LU/233/14/NMA

From: Charlotte Burrows
Sent: 22 August 2014 10:00
To: [REDACTED]
Subject: RE: Decking changes

DRAWING NO:	REVISION:
1043/1	A

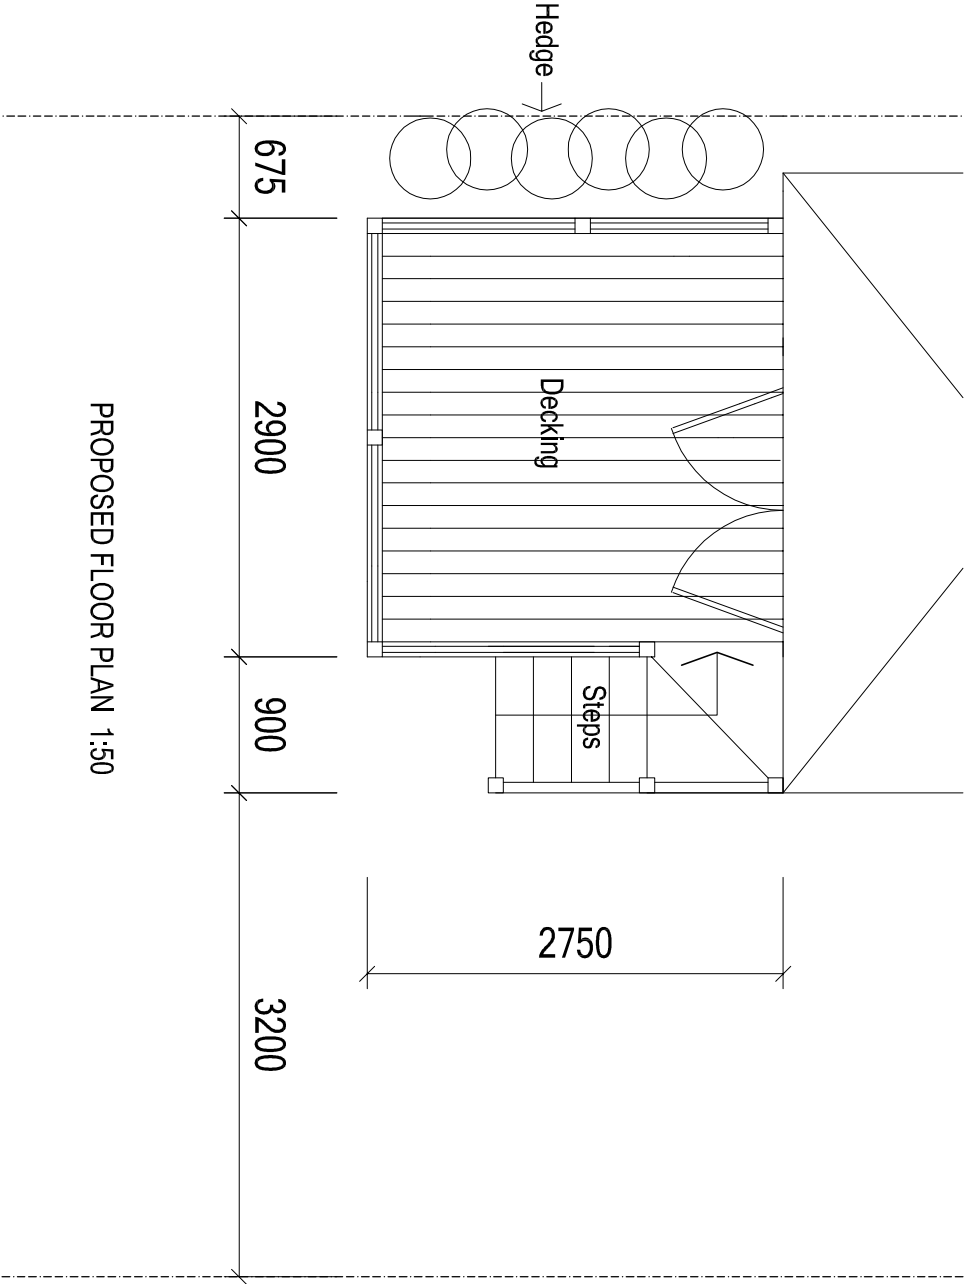
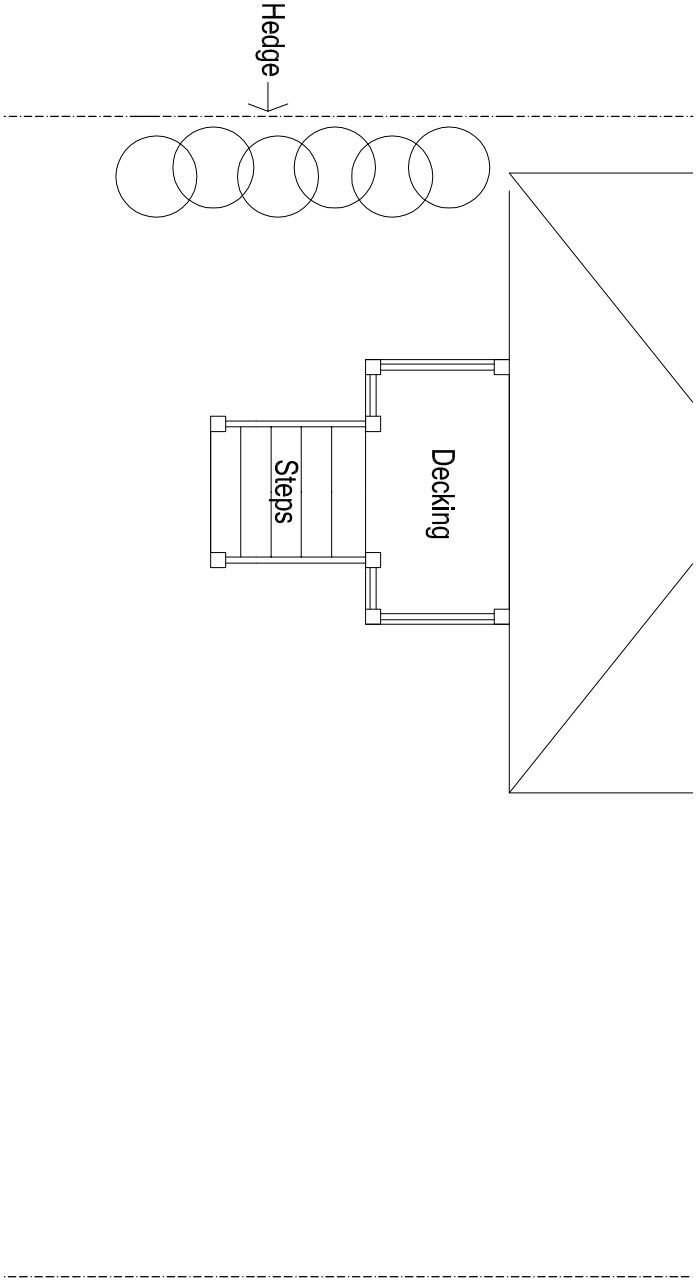
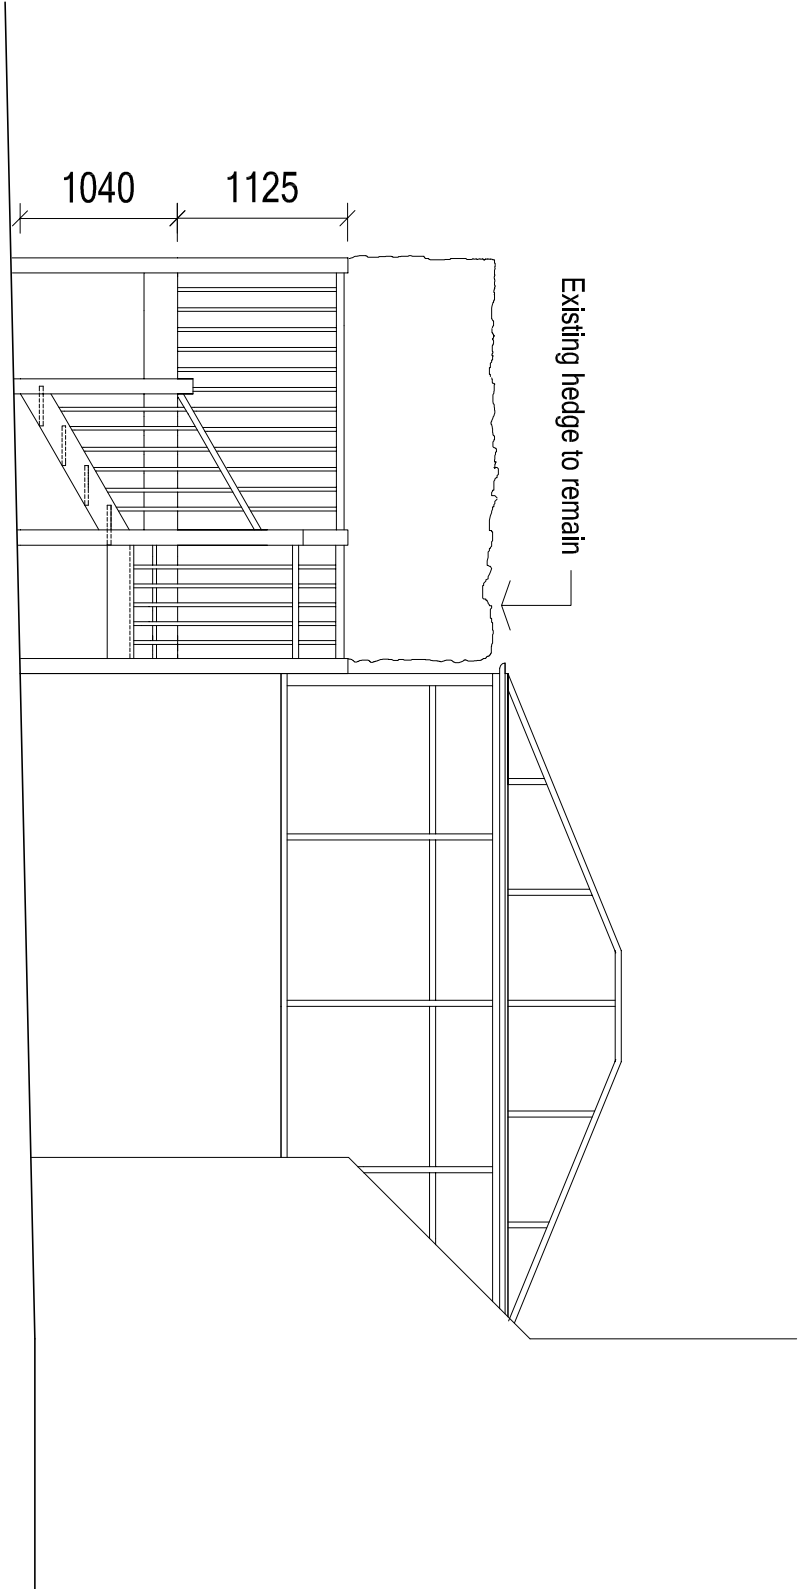
Unfortunately the drawings submitted are still omitting to show the hedge, I have discussed this with the Team Leader for the area and we will require the hedge to be clearly indicated on the proposed plans.
